**COMMENTS ON THE RELEVANT REPRESENTATIONS
SUBMITTED TO THE EXAMINATION BY INTERESTED
PARTIES**

Document reference: AU/KCW/LZH/1724/01/RR
March 2022

PINS document reference: 9.1

**PLAN SHOWING THE APPROXIMATE ROUTE OF DRAINAGE CULVERTS BENEATH
THE CENTRAL AREA OF THE PROPOSED WESTERN EXTENSION**

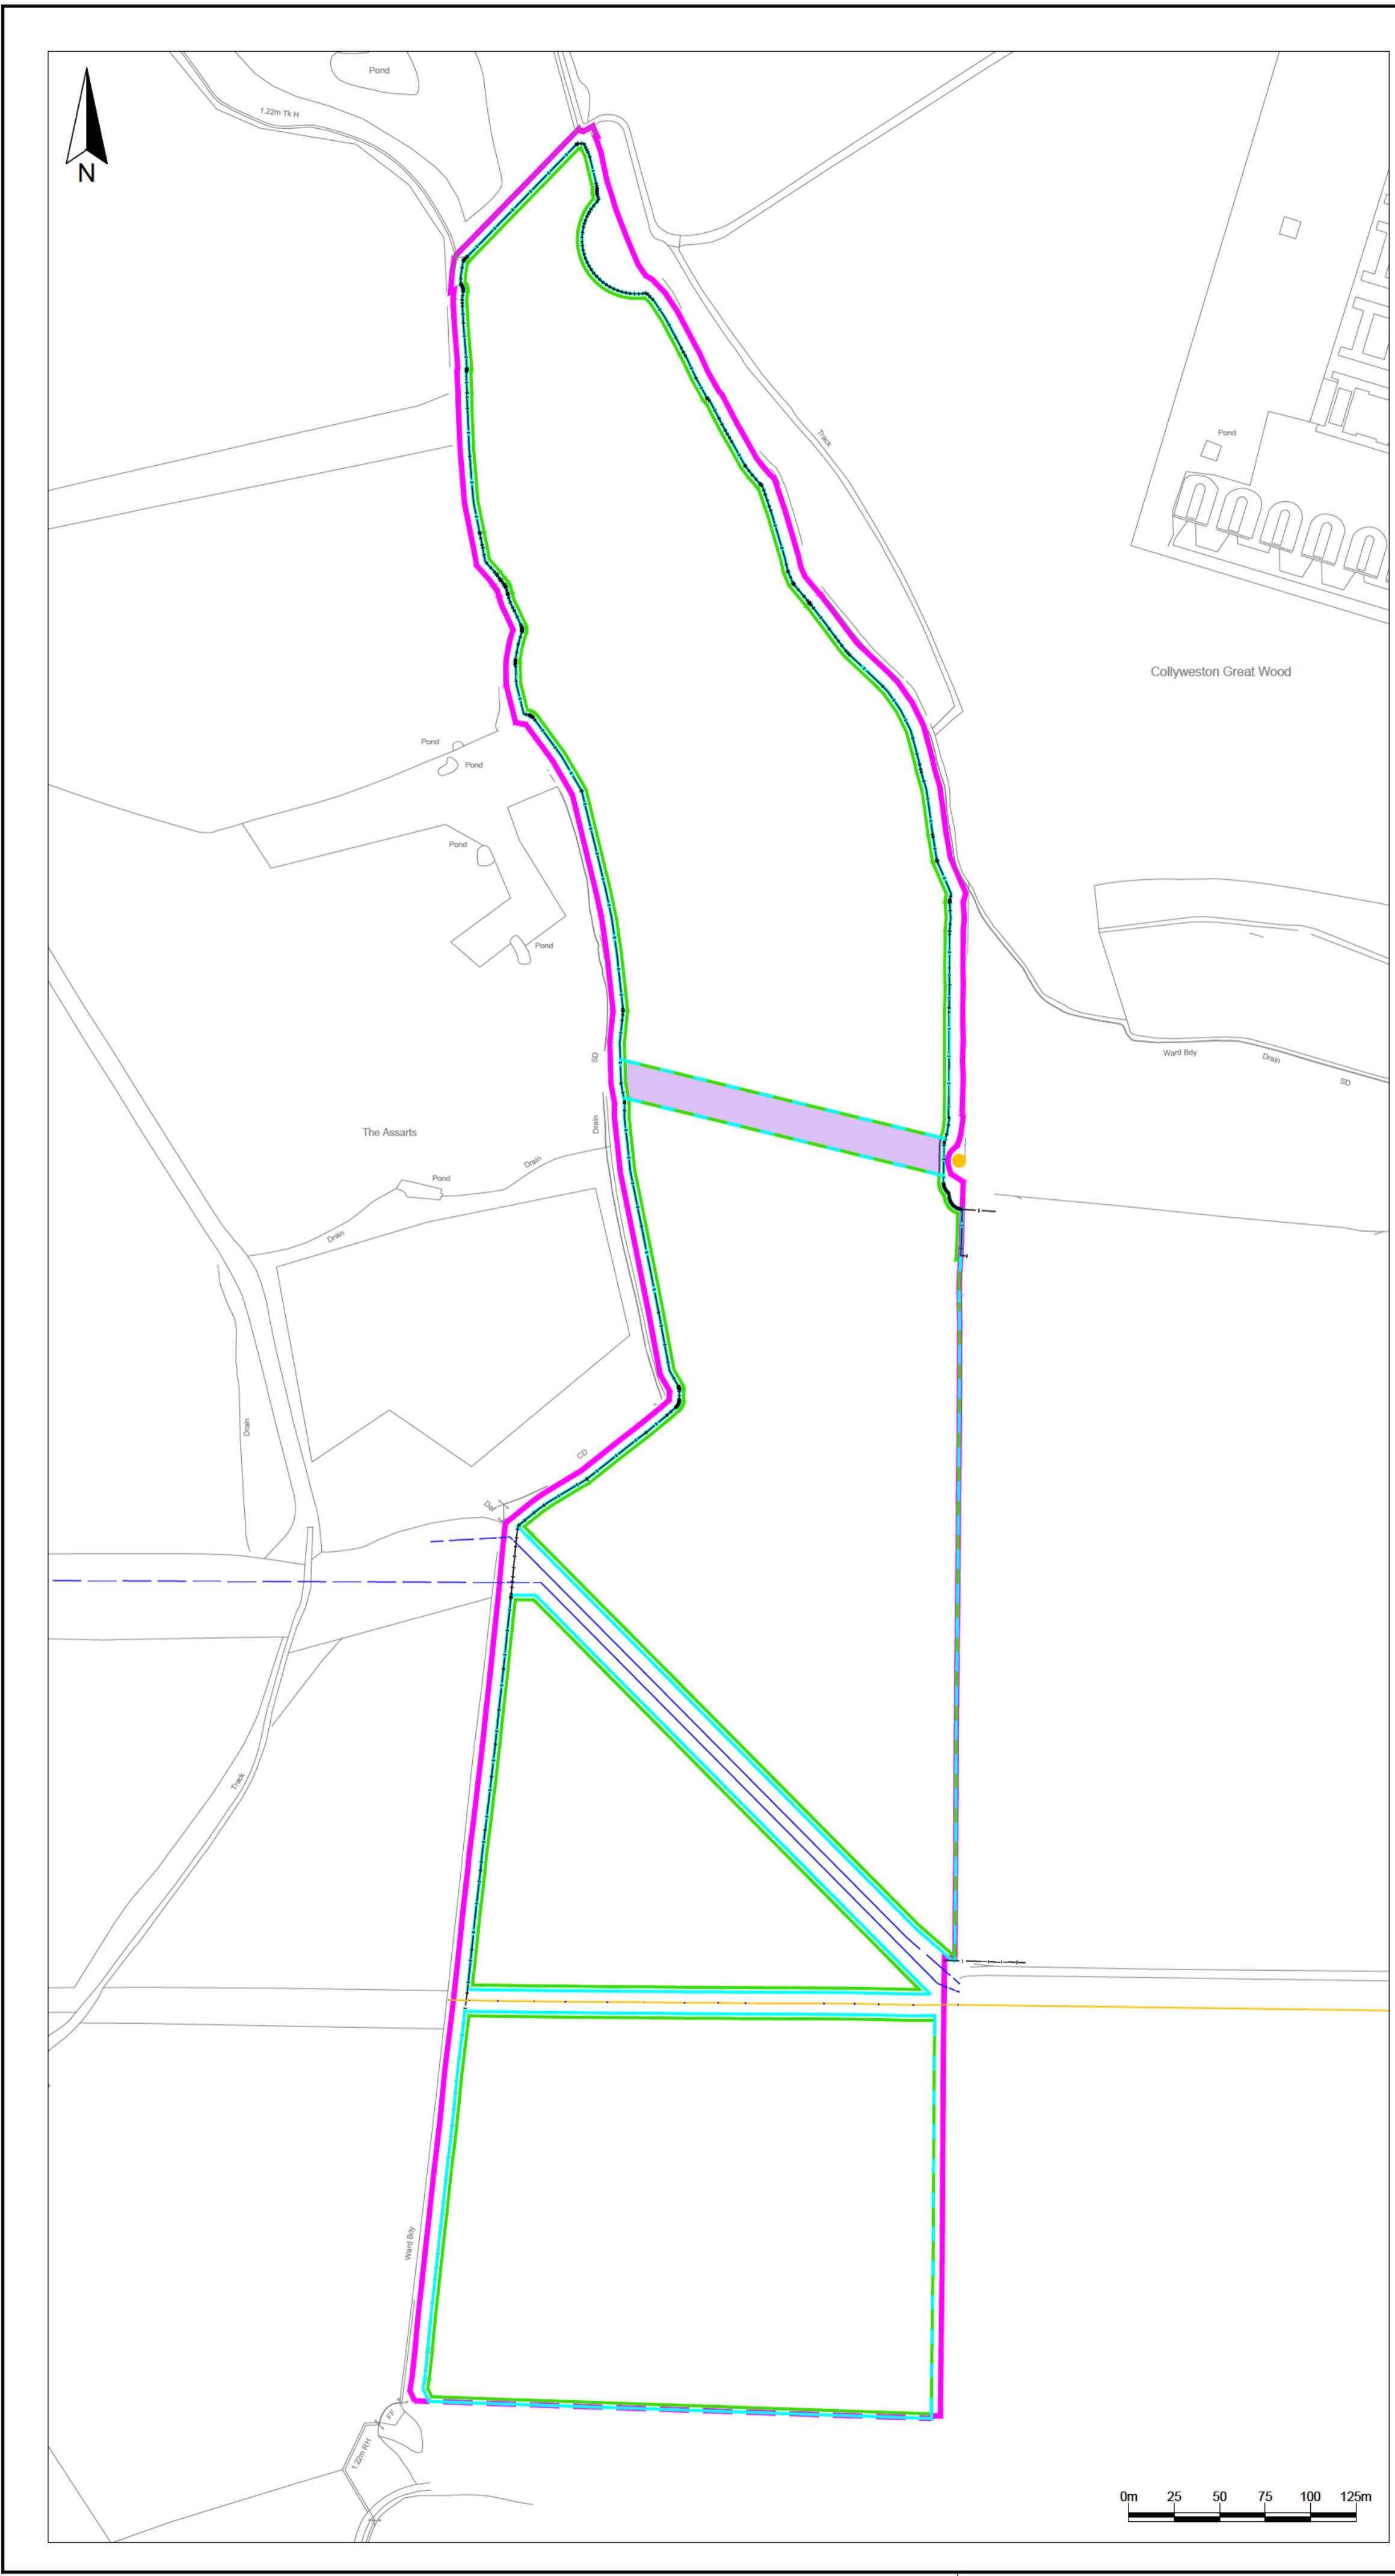
Date received	Representation	Comments from Augean South Ltd
	<p>surface water management strategy which forms part of the Environmental Statement.</p>	
	<p>2. There is a lack of clarity about how the proposed surface water will be channelled from the site. There are several references to an west-east drainage channel, but the design of it is left to a later stage rather than forming part of the application, so it is not clear how water will discharge from the site.</p>	<p>The detailed proposals for the management of the surface water at the site are set out in the Surface Water Management Plan (SWMP) provided at Appendix ES18.2 (PINS document reference 5.4.18.2. APP-095) including the function and location of the west-east drainage channel and the routes by which water will discharge from the site.</p> <p>The aspects of the SWMP which remain subject to detailed designs are controlled through Requirement 3(4) of the draft DCO. The principles of the approach to the SWMP are agreed by North Northamptonshire Council who are the Lead Local Flood Authority for the area which includes the site and NNC have agreed that the approval of the detailed drainage designs will be subject to approval through Requirement 3(4) of the draft DCO. The detailed designs will not change the agreed principles.</p>
